Application Number SSI 7485**WestConnex M4-M5 Link – Modification 2 The Crescent overpass****Keith Scott**

SSI 7485

Figure 4-1 Overview of the proposed modification

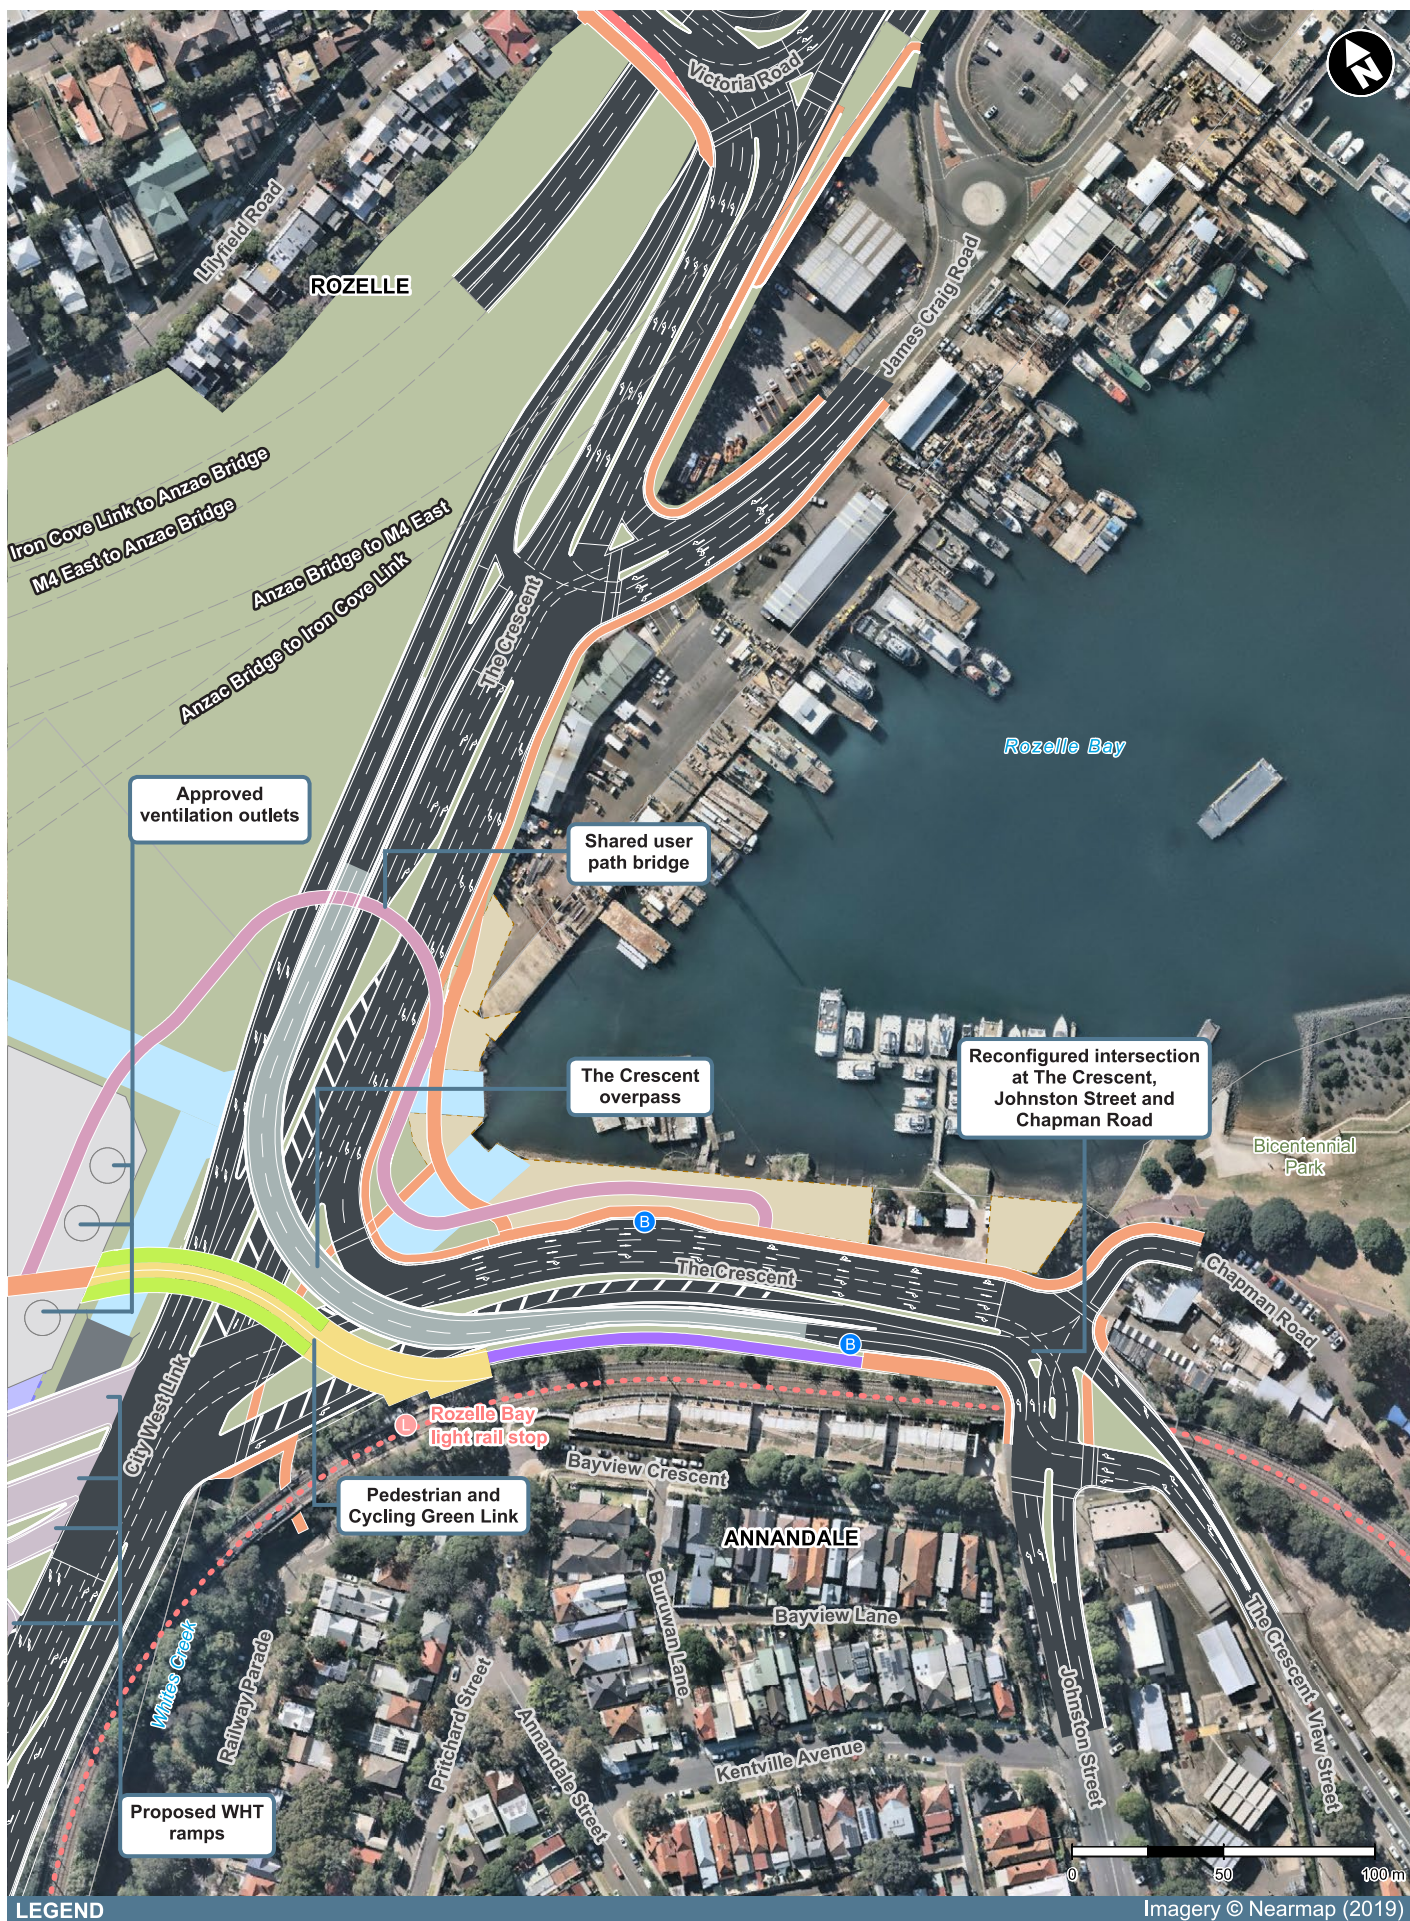
The proposed overpass is totally out of step with local development in Annandale and will obstruct a local heritage mural and destroy Buruwan Park. Reconsideration should be given to obvious alternatives such as an **underground tunnel** running under Whites Creek.

This proposal could be replaced with a slot cut and cover trench running under Whites Creek to push traffic underground instead of overground and avoid the massive imposition of an overpass and destruction of the 'people's mural'.

pedestrian and cycling green link to connect the Rozelle Goods Yard to Bicentennial Park. Relocating that green link to the west of the intersection of The Crescent and City West Link ignores the original conditions of consent given for this project and puts the needs of motorists ahead of pedestrians and cyclists.

The proposed pedestrian bridge further north up the City West Link creates an unnecessarily long walk for pedestrians and an unnecessarily high climb of 5+ metres.

Figure 4-5 The Crescent/Johnston Street/Chapman Road intersection

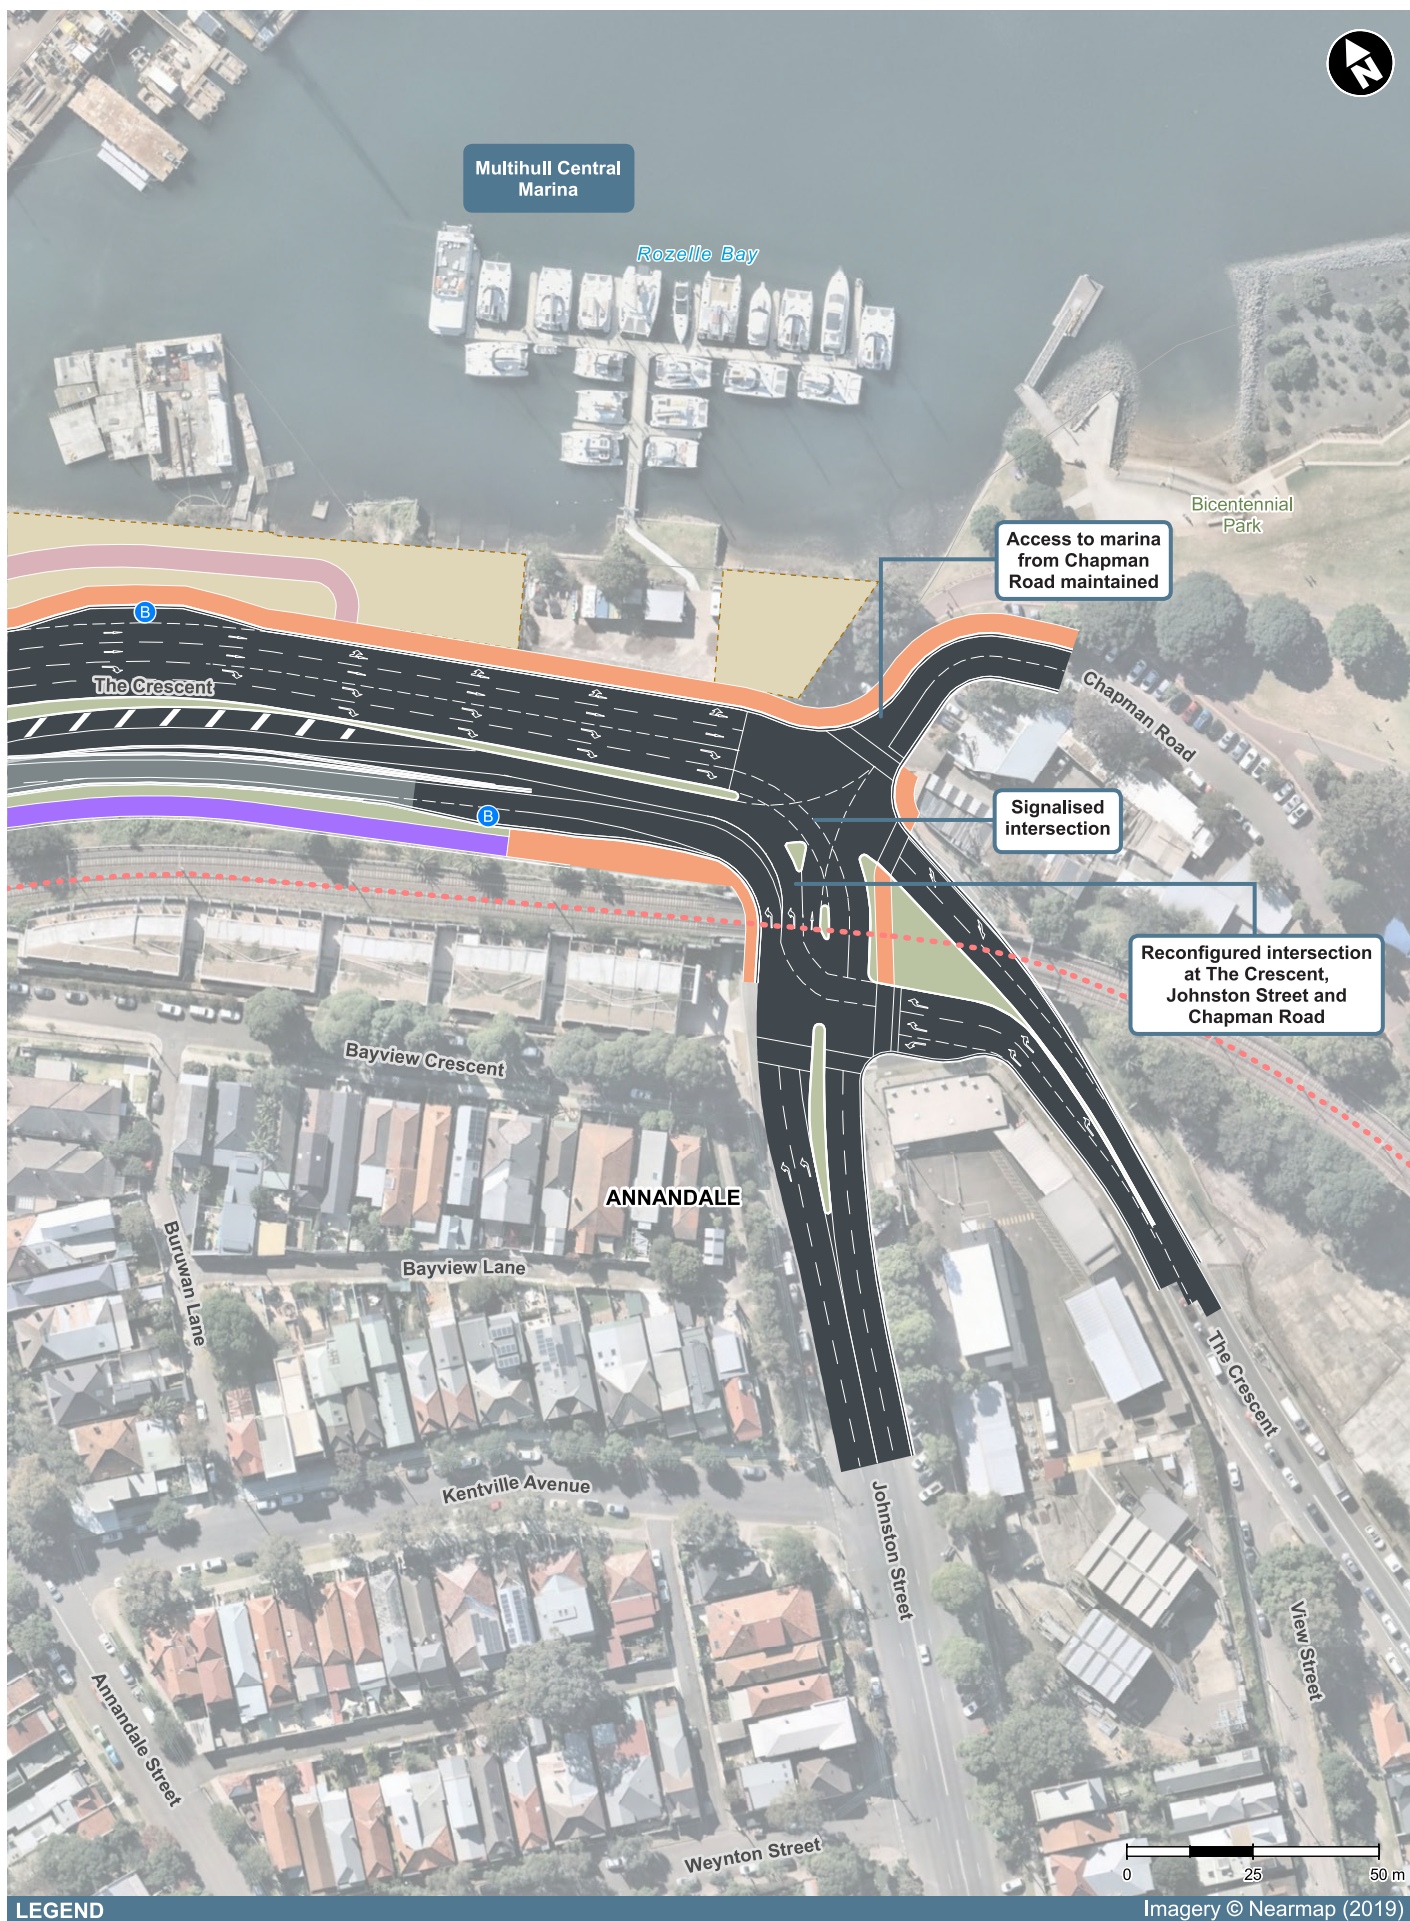
This modification prioritises the needs of motorists, trashing the experience of local pedestrian traffic and making it harder for residents to access the public waterfront. Pedestrians walking from the Western side of Johnston Street will have to use an astonishing four pedestrian crossings in order to reach Bicentennial Park. This pedestrian arrangement should be modified to allow pedestrians to cross direct from Johnston Street to the Park via The Crescent.

Figure 4-6 Elevation: Indicative view of Rozelle Rail Yards Pedestrian and Cycling Green Link

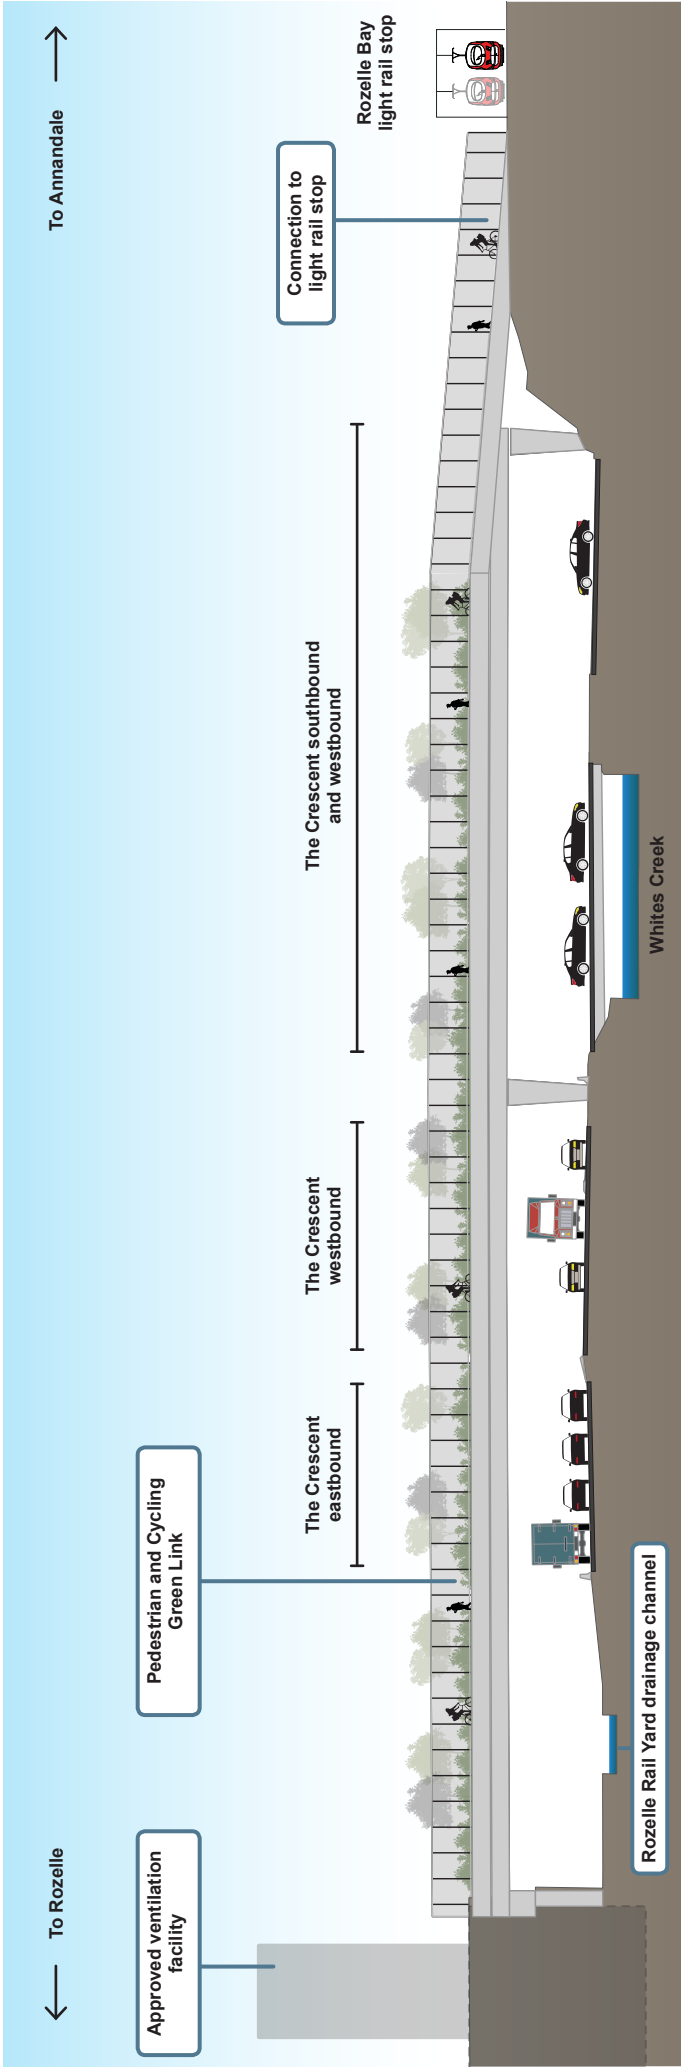
This modification would abandon one of the centrepieces of the original design: a

RMS and the contractors should reconsider other design options for a continuous green link from Rozelle Goods Yard, across the City West Link into Jubilee Park, including a link to Annandale and the Rozelle Bay light rail stop.
